**Re: Sprinstone parking
Davenport st NW
Traffic Circulation Layout**
Engineer's/Architect's Stamp 09-18-2019 (C12D003B2)

Based upon the information provided in your submittal received 09-18-2019, the above referenced plan cannot be approved for Building Permit until the following comments are addressed:

SPRINGSTONE PARKING LOT AND GARAGE TRAFFIC CIRCULATION PLAN

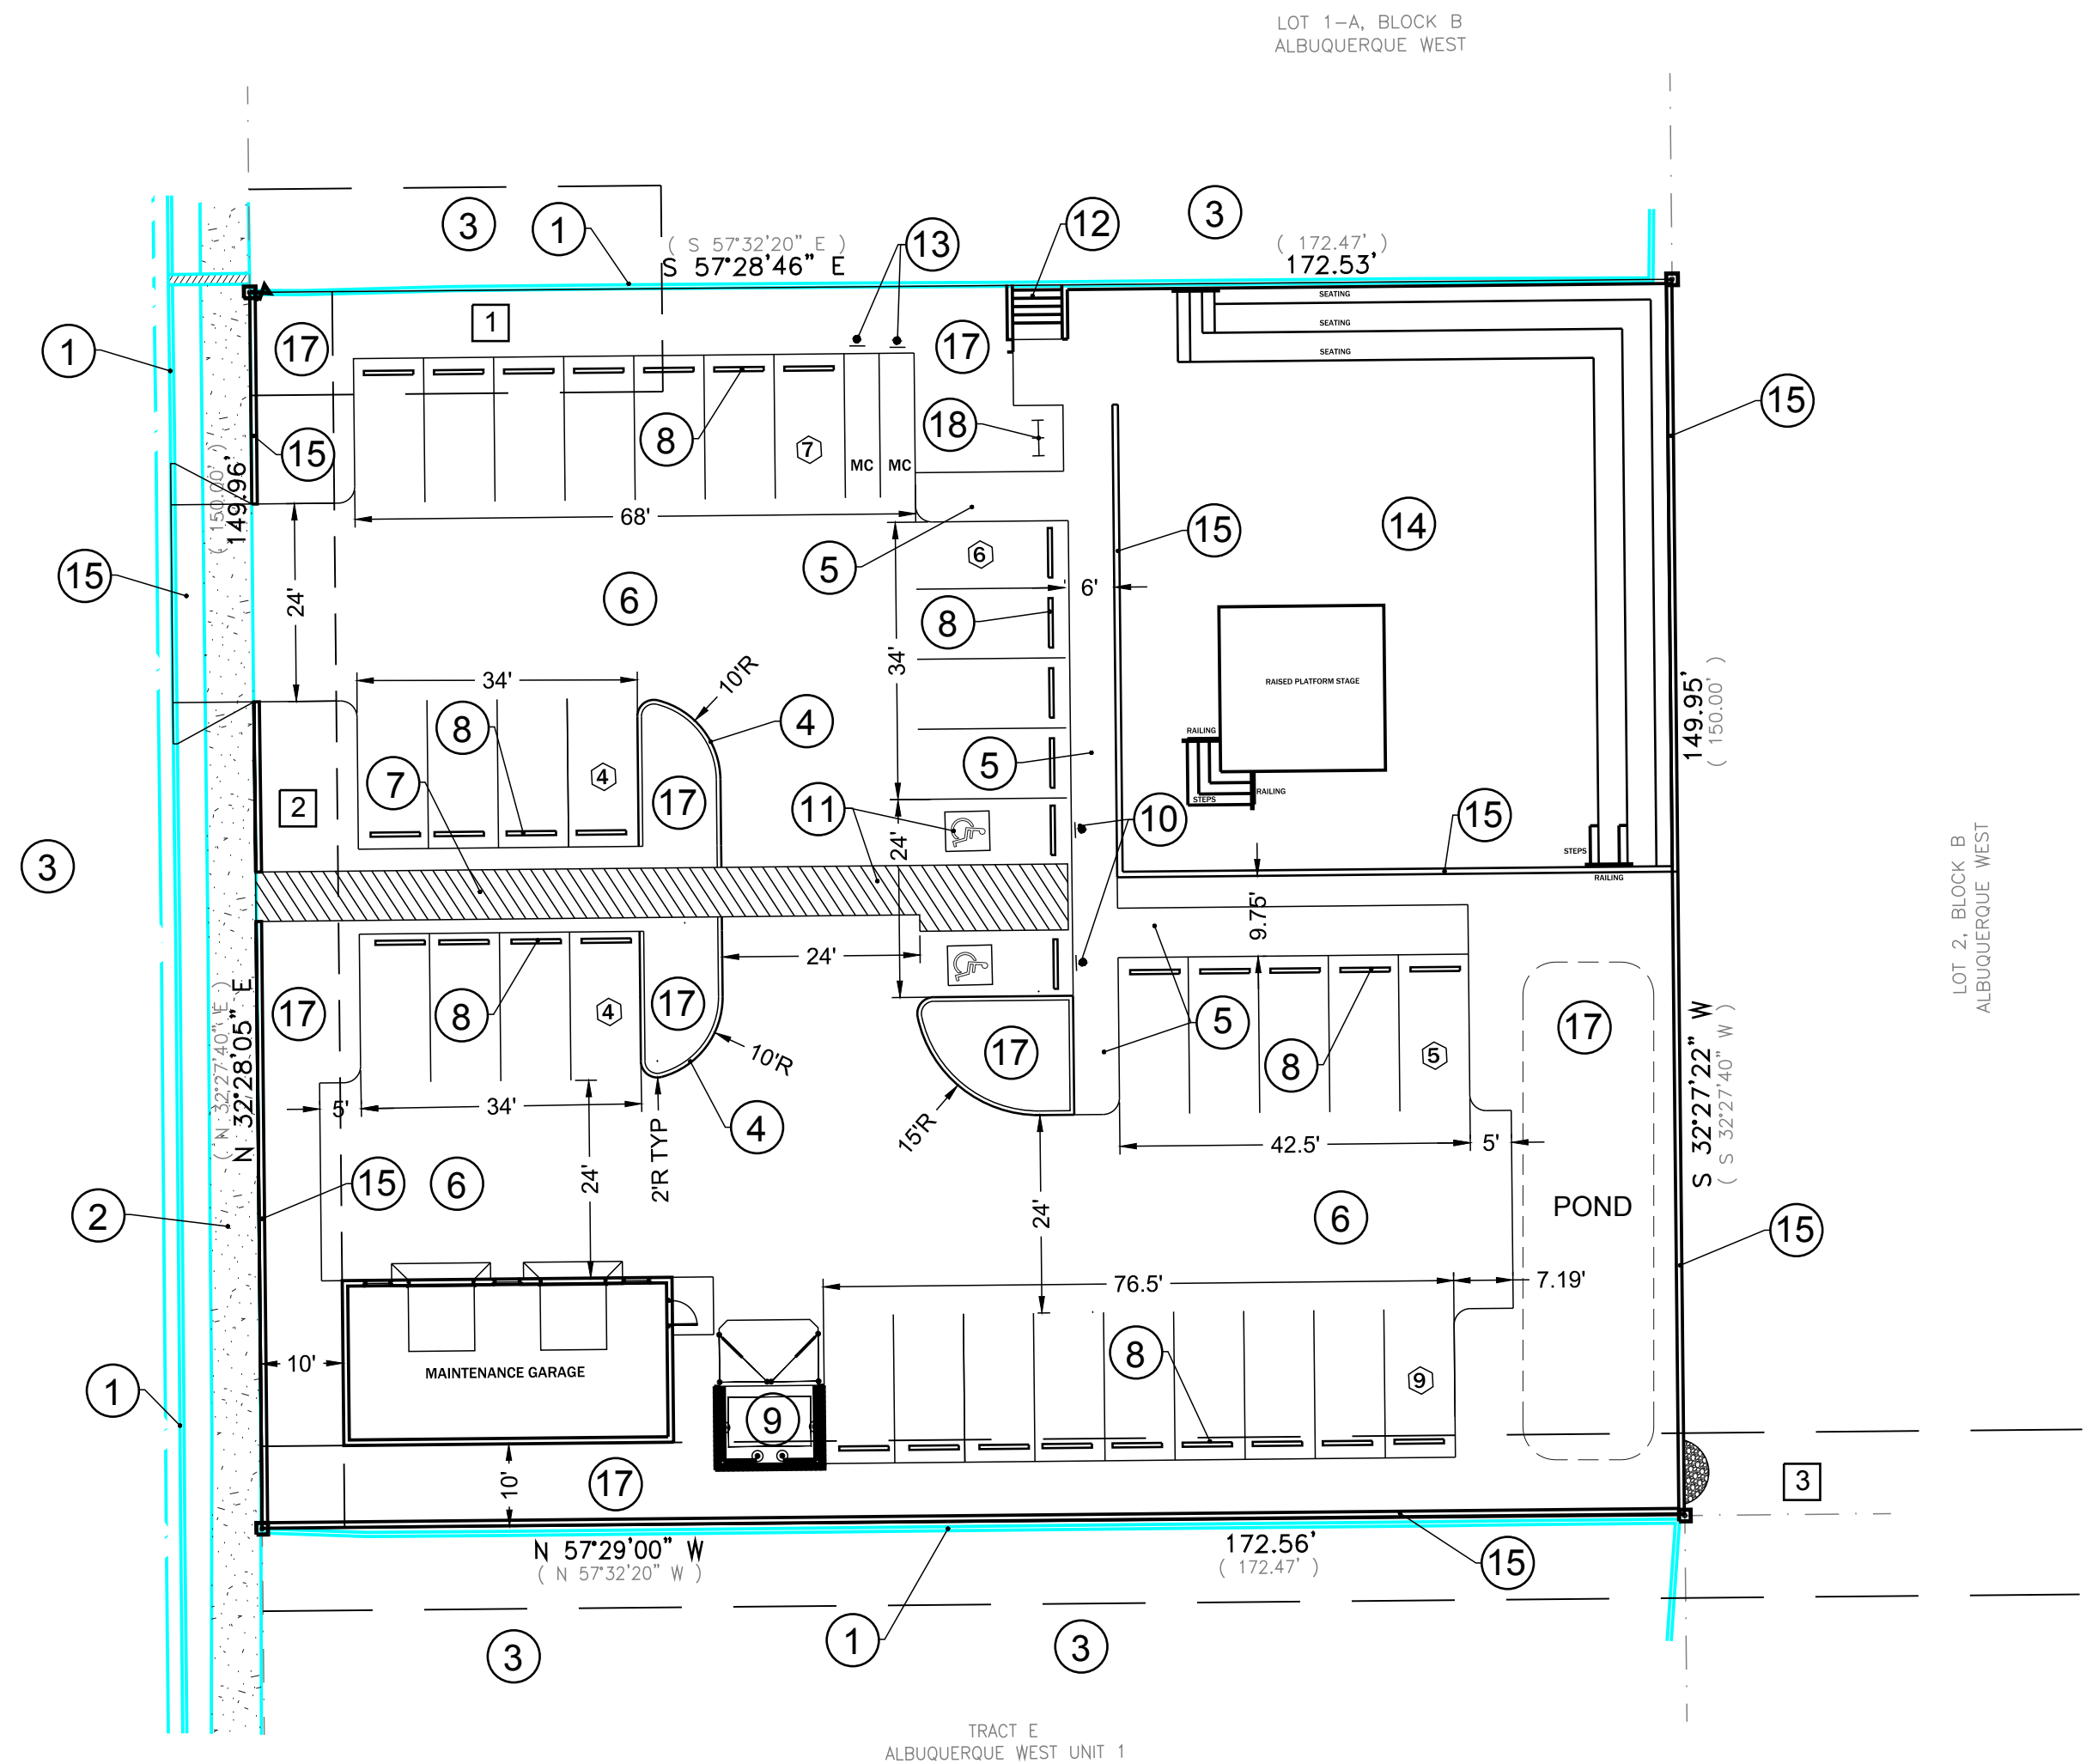
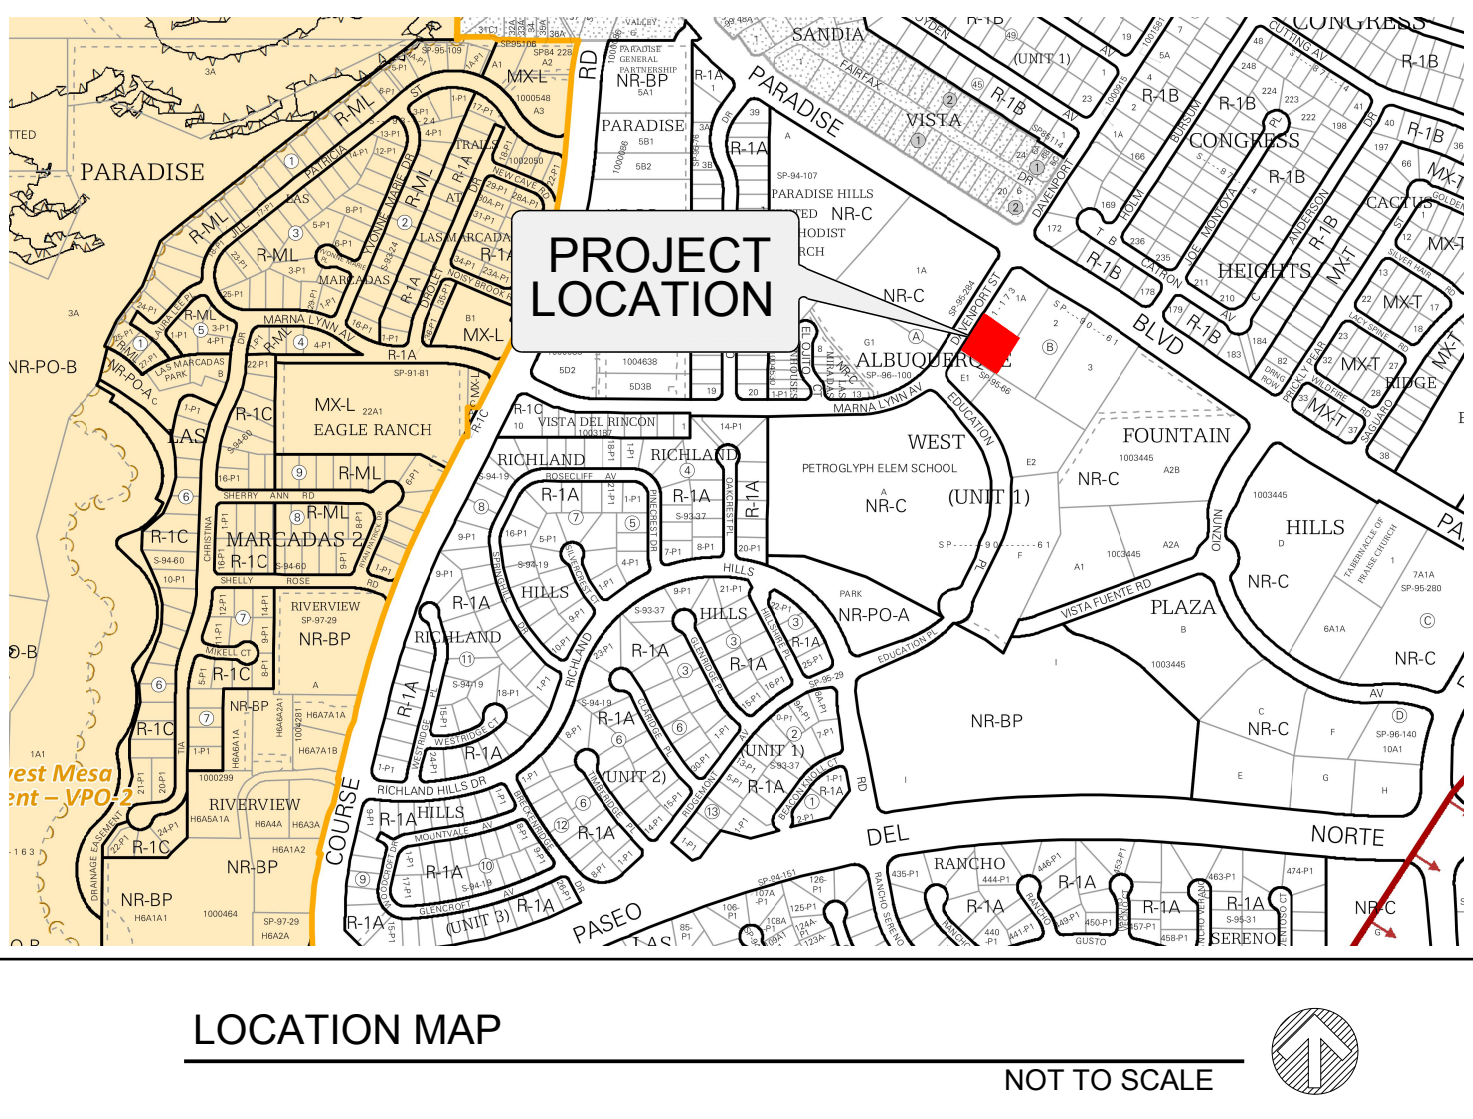
1. The ADA access aisles shall have the words **"NO PARKING"** in capital letters, each of which shall be at least one foot high and at least two inches wide, placed at the rear of the parking space so as to be close to where an adjacent vehicle's rear tire would be placed. (66-1-4.1.B NMSA 1978)

6. Per DPM, a 6 ft. wide ADA accessible pedestrian pathway is required from the ADA parking stall access aisles to the building entrances. Please clearly show this pathway and provide details.

7. Refuse vehicle maneuvering shall be contained on-site. The refuse vehicle shall not back into the public right of way.; **provide a copy of refuse approval.**
8. It is not apparent what type of pavement surface is being proposed. A hard driving surface will be required as part of this proposed project for parking area and drive aisles.
9. Show the clear sight triangle and add the following note to the plan:
"Landscaping and signage will not interfere with clear sight requirements. Therefore, signs, walls, trees, and shrubbery between 3 and 8 feet tall (as measured from the gutter pan) will not be acceptable in the clear sight triangle."
